DRAWN BY: O.E. WATTS	APPROVED BY:	REVISIONS	OLIVER E. WATTS CONSULTING ENGINEER COLORADO SPRINGS	PROJECT 16140 OLD DENVER ROAD PART NW1/4 SEC. 26, T.11S., R.67W, 6TH P.M. EL PASO COUNTY	SHT. NAME CONSTRUCTION DOCUMENT COVER SHEET	SHT. NO. 1 OF 3	
	DATE: 10-23-19	PROJ. NO.						
	DWG. NO.: 17-4958-06	DWG.

PROJECT 16140 OLD DENVER ROAD  
PART NW1/4 SEC. 26, T.11S., R.67W. 6TH P.M.  
EL PASO COUNTY

## GRADING AND EROSION CONTROL PLAN

PROFILE - POND AND OUTLET
SCALE: H:1"=50'
V:1"=5'

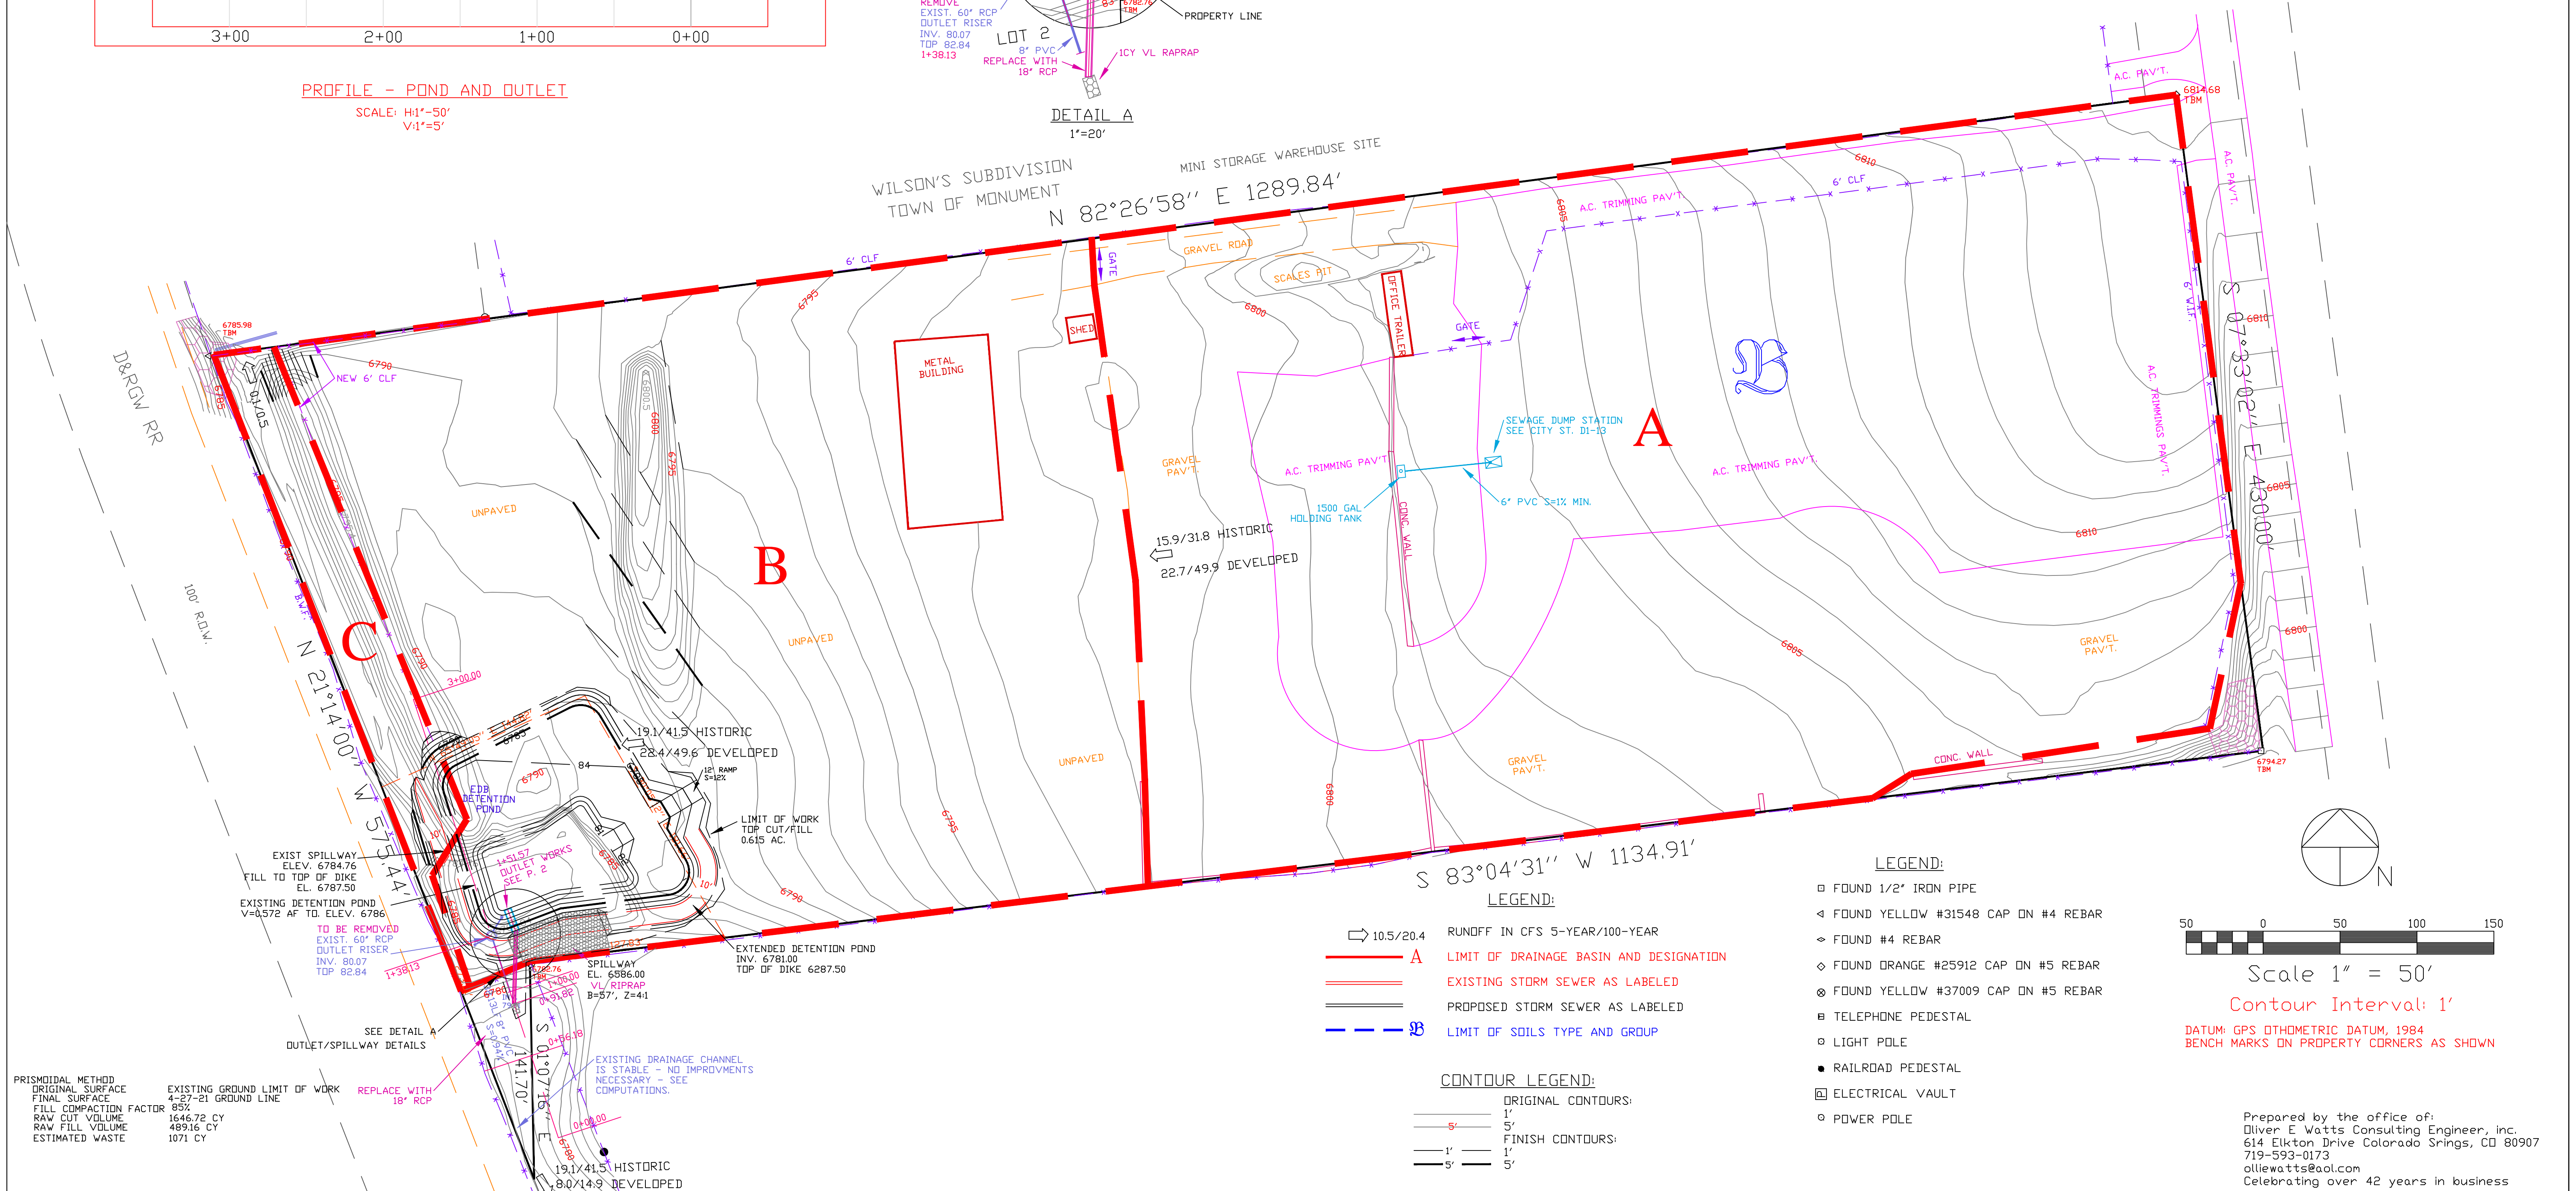
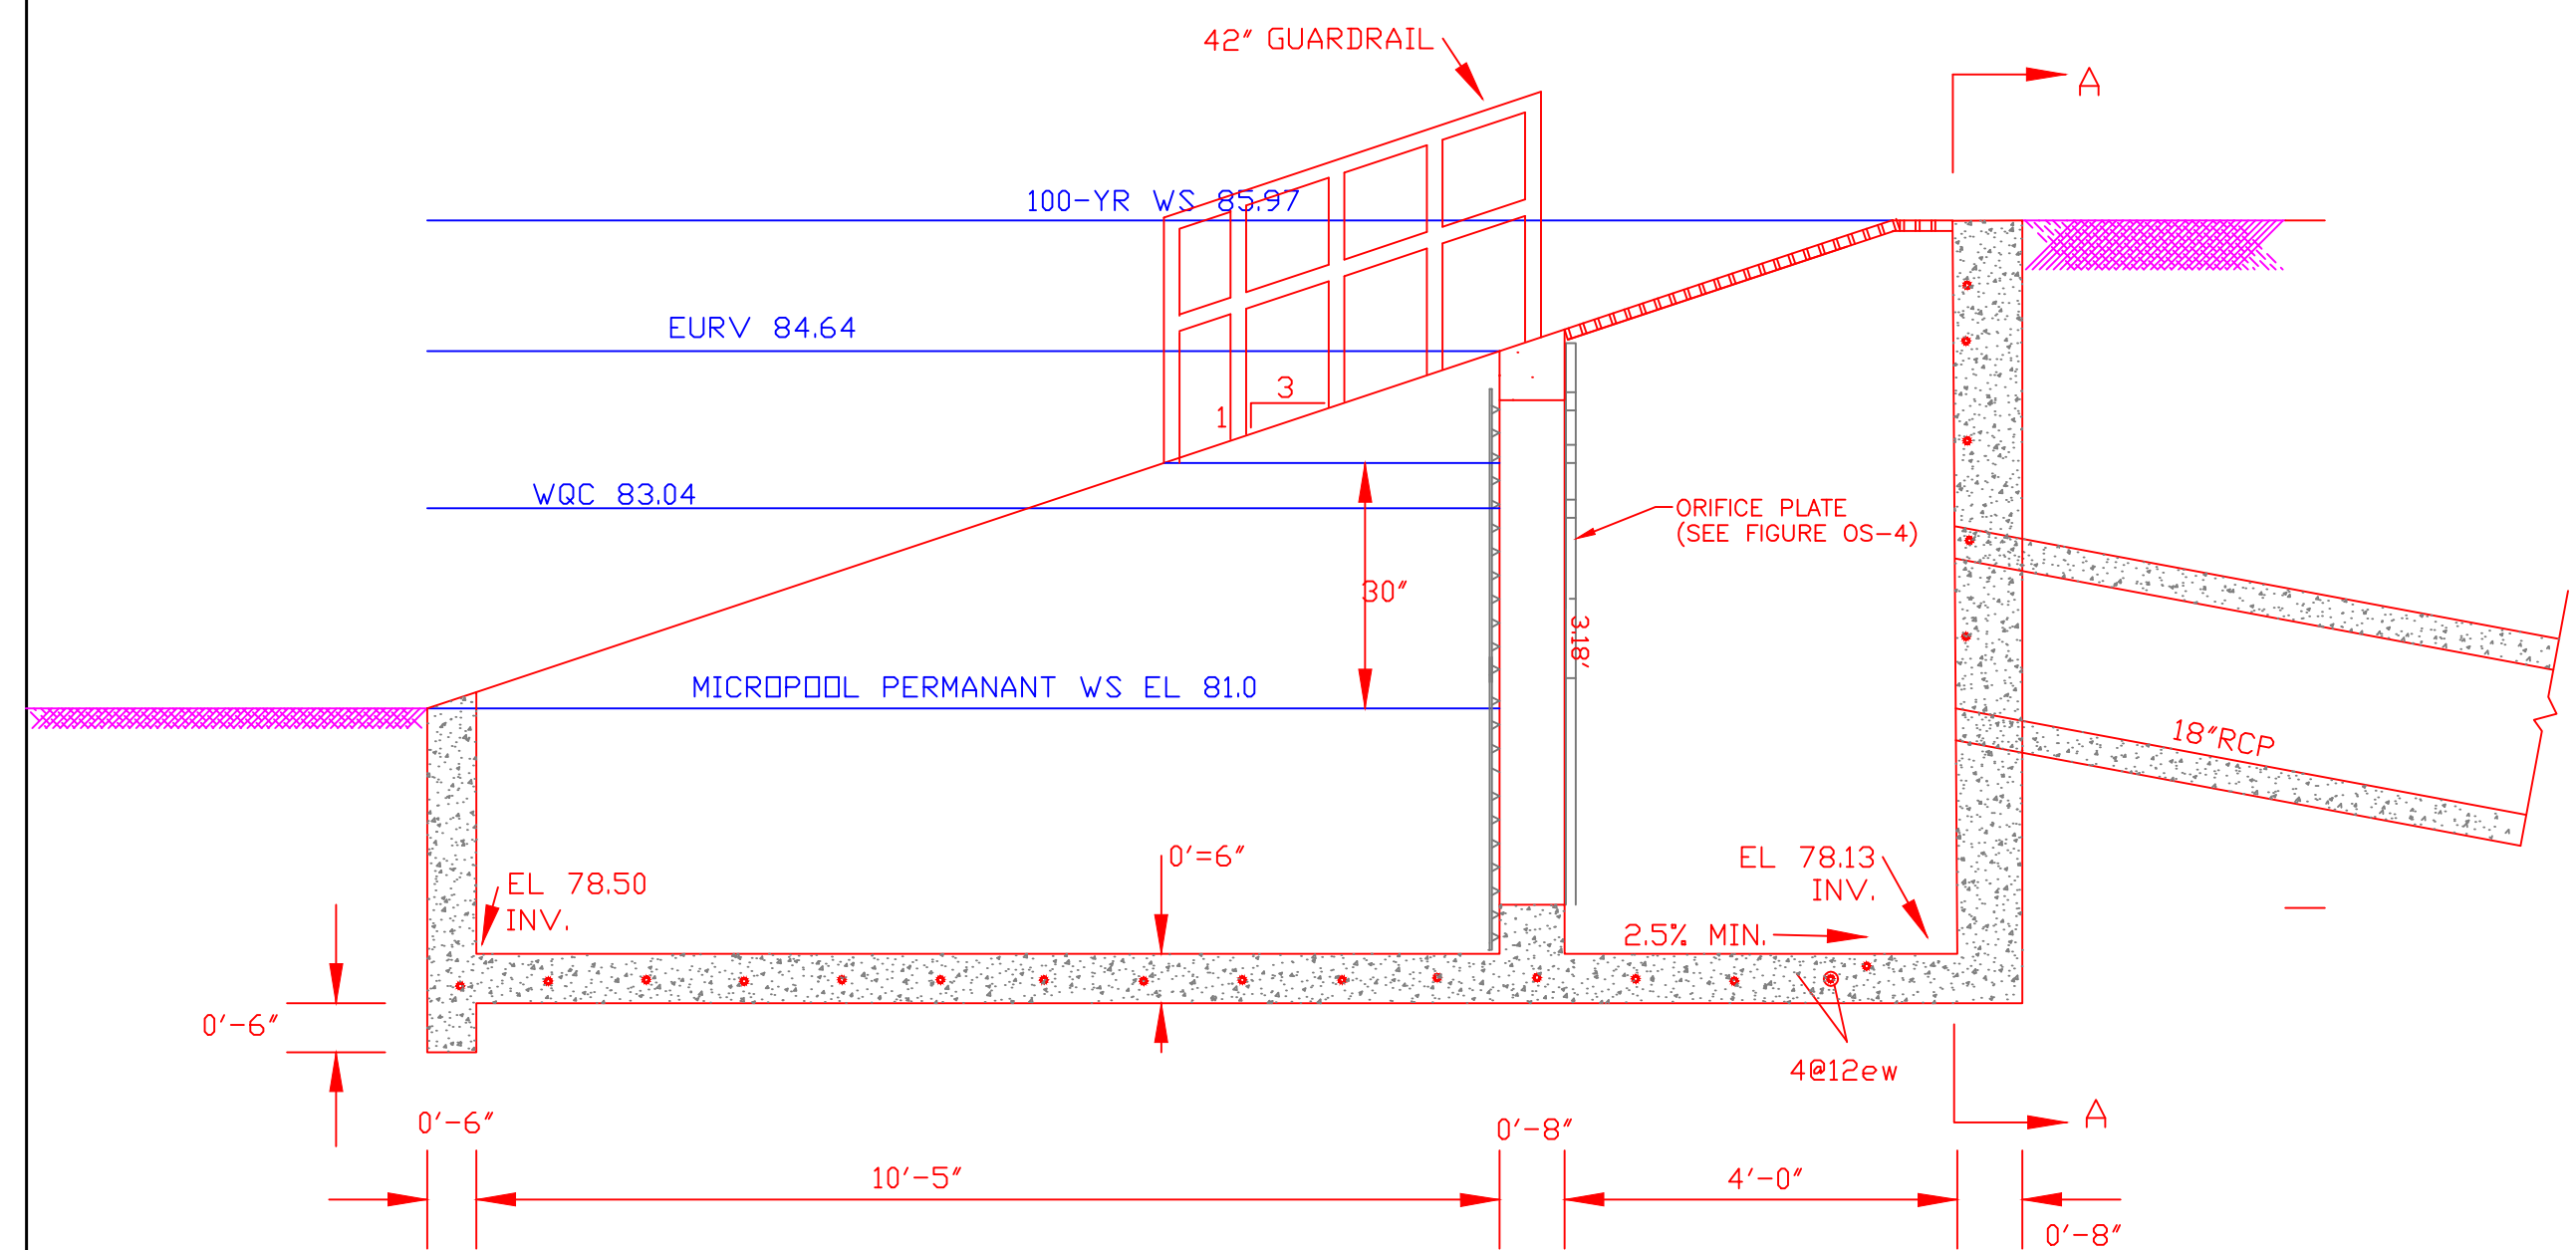
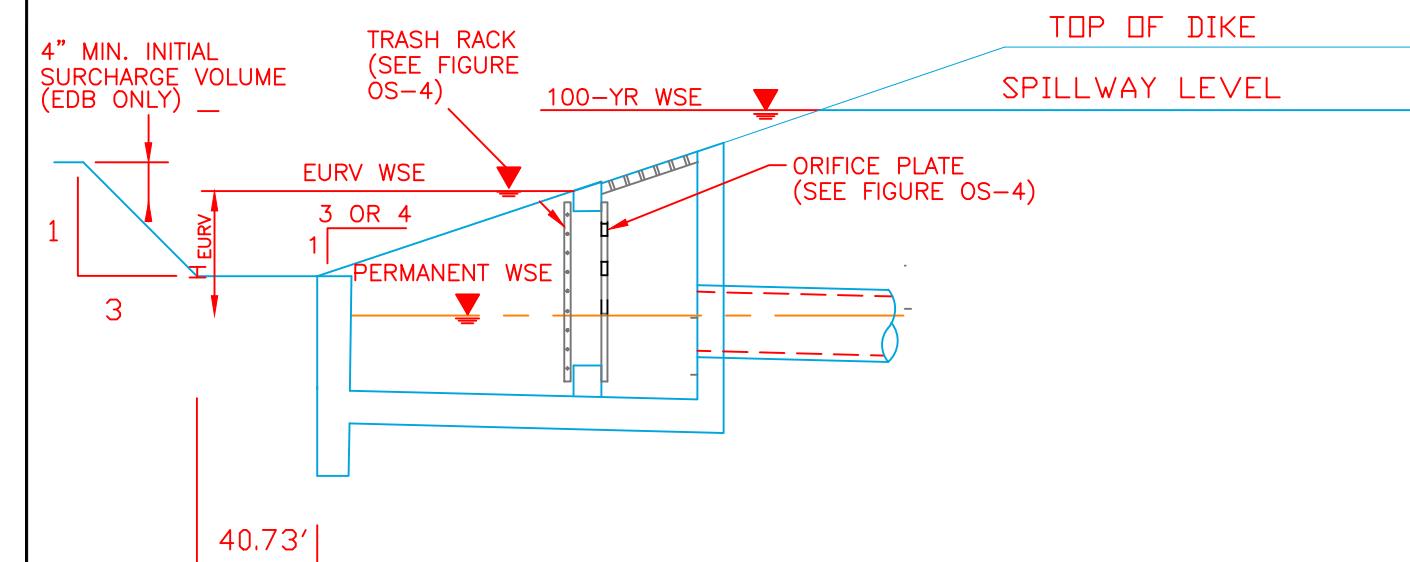
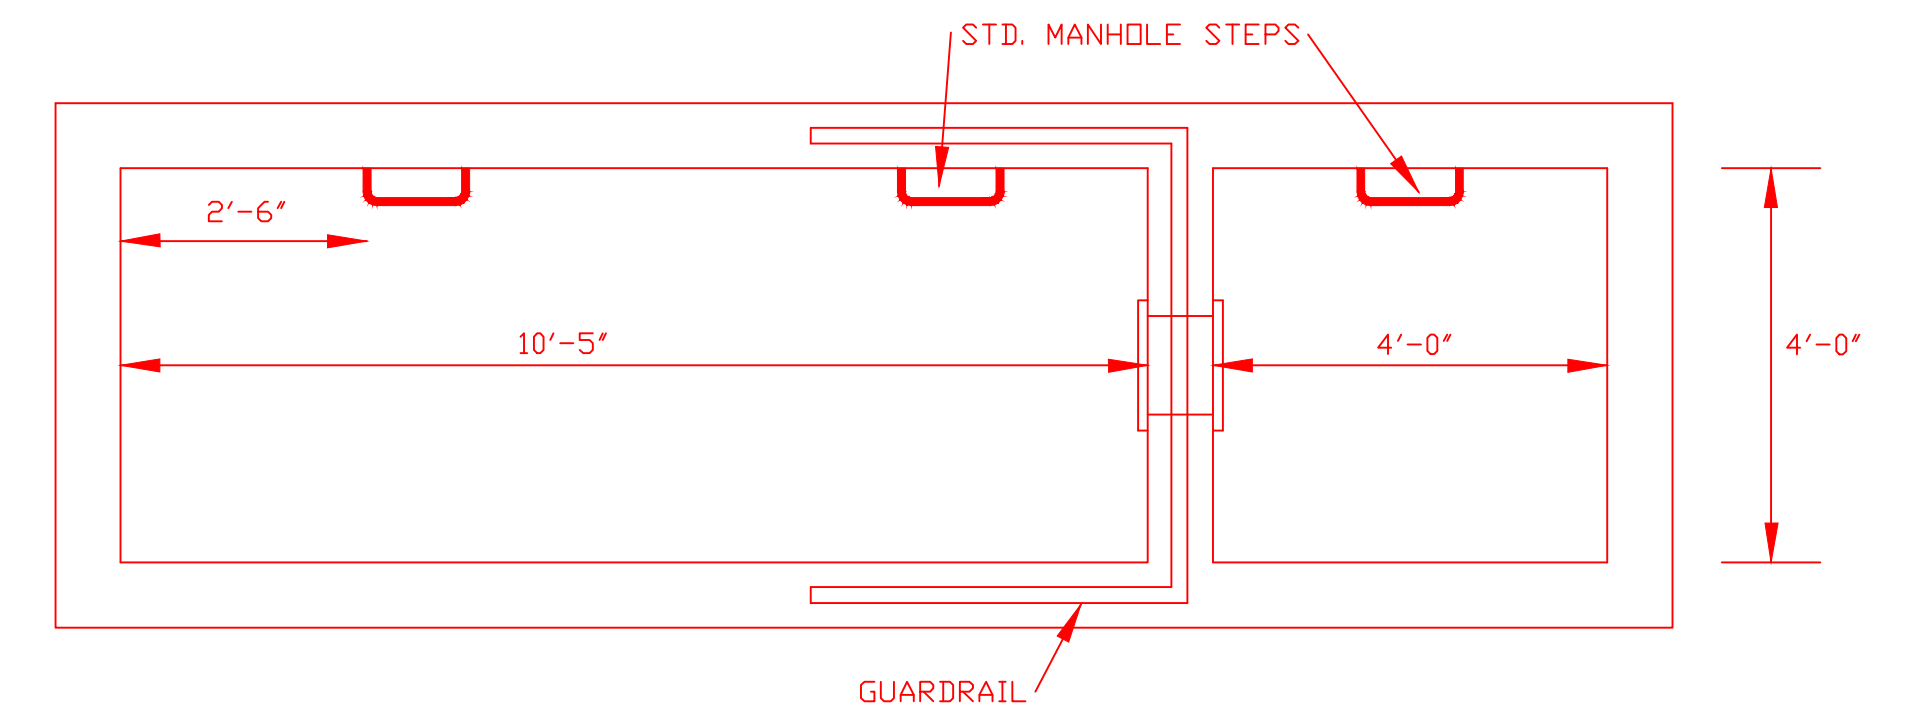
This does not meet the criteria for a full spectrum extended detention basin outlet structure discussed during the October 7, 2019 meeting.

- Unresolved. Extended Detention Basin construction details are missing. During the meeting the expectation was to construct the pond as an extended detention basin.
- The extended detention basin is missing the following components:
- maintenance access ramp
  - forebay
  - trickle channel
  - micropool
  - outlet structure design for FSD
  - spillway cross section
- Below are examples.
